CITY OF ELLENSBURG

Memorandum

Date: December 8, 2022
To: Chace Pedersen, County Planner I
From: Craig Jones, Development Coordinator 
Through: Derek Mayo, City Engineer
Re: SEPA for 1111 E Bowers Rd – SE-22-00065

The following are the City Public Works comments for the proposed Airplane Hanger project on the property at 1111 E bowers Rd.

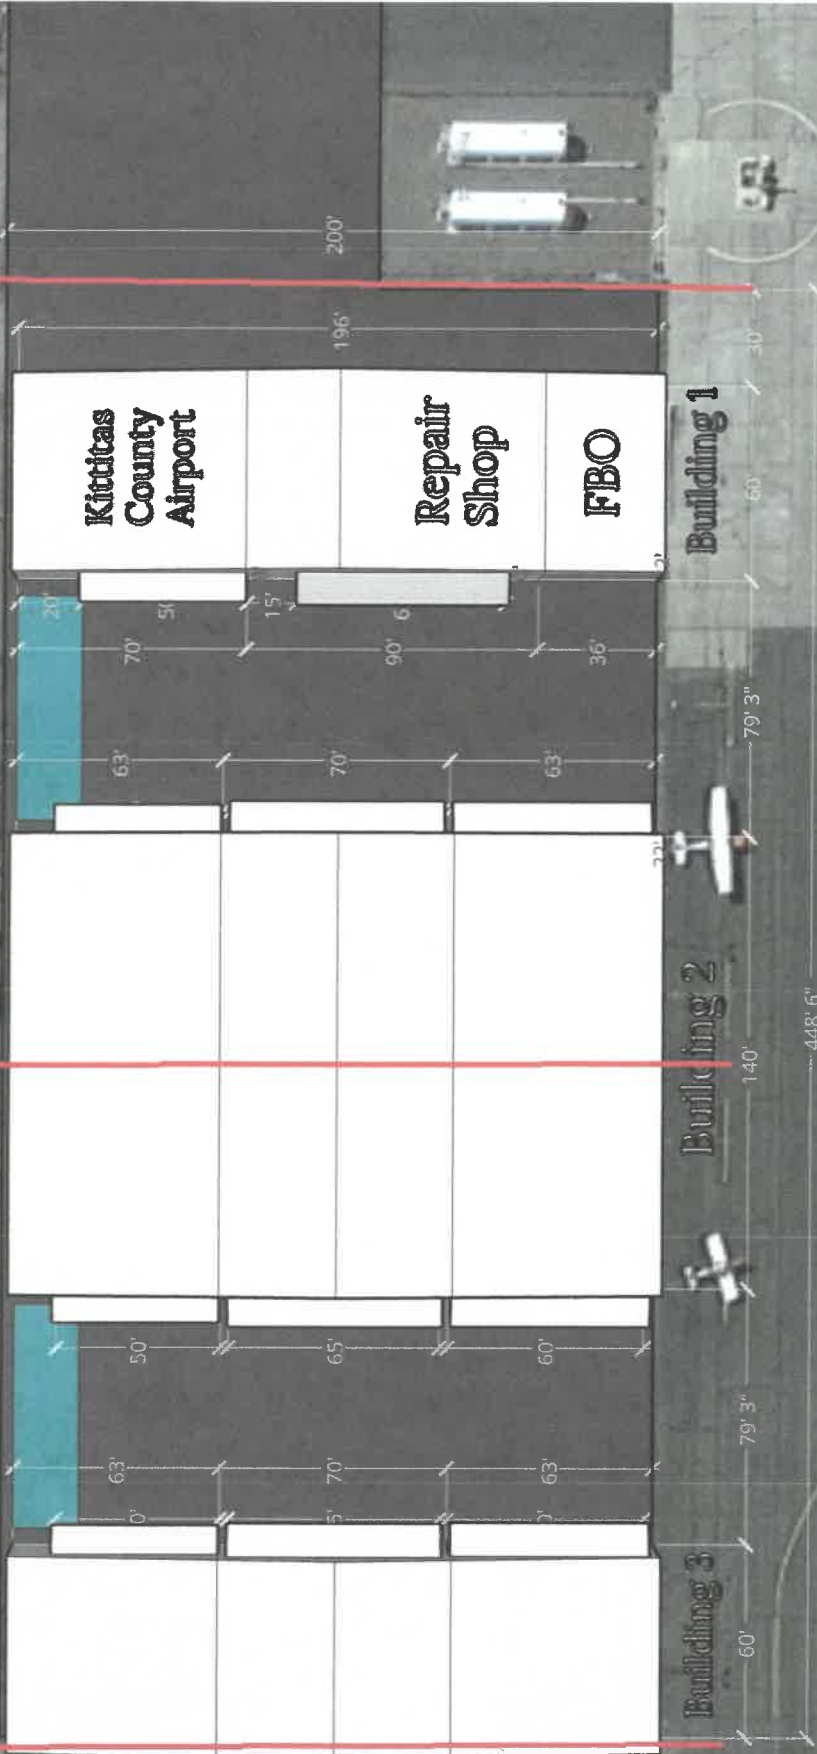
A 16" Ductile Iron water main runs in Bowers Rd along the property. There are several 2" stubs to the property for potential use. Any Fire Service or Fire Hydrant placement shall be per Fire Dept. requirements and shall be constructed per City Development standards. Your engineer may need to verify adequate water at all fire hydrants. See attached utility map.

Backflow devices will be required on the new services. Specific issues related to water service and meter locations will be addressed at project civil submittal.

An 8" PVC sewer main runs along the Bowers Rd frontage. There are several 6" sewer stubs to the property for potential use. See attached utility map.

Specific issues related to the sewer main and service connection(s) will be addressed through the projects civil submittals.

Additional utility easements may be required for any proposed utility outside of the right of way. Specific issues will be addressed at civil plan submittal.
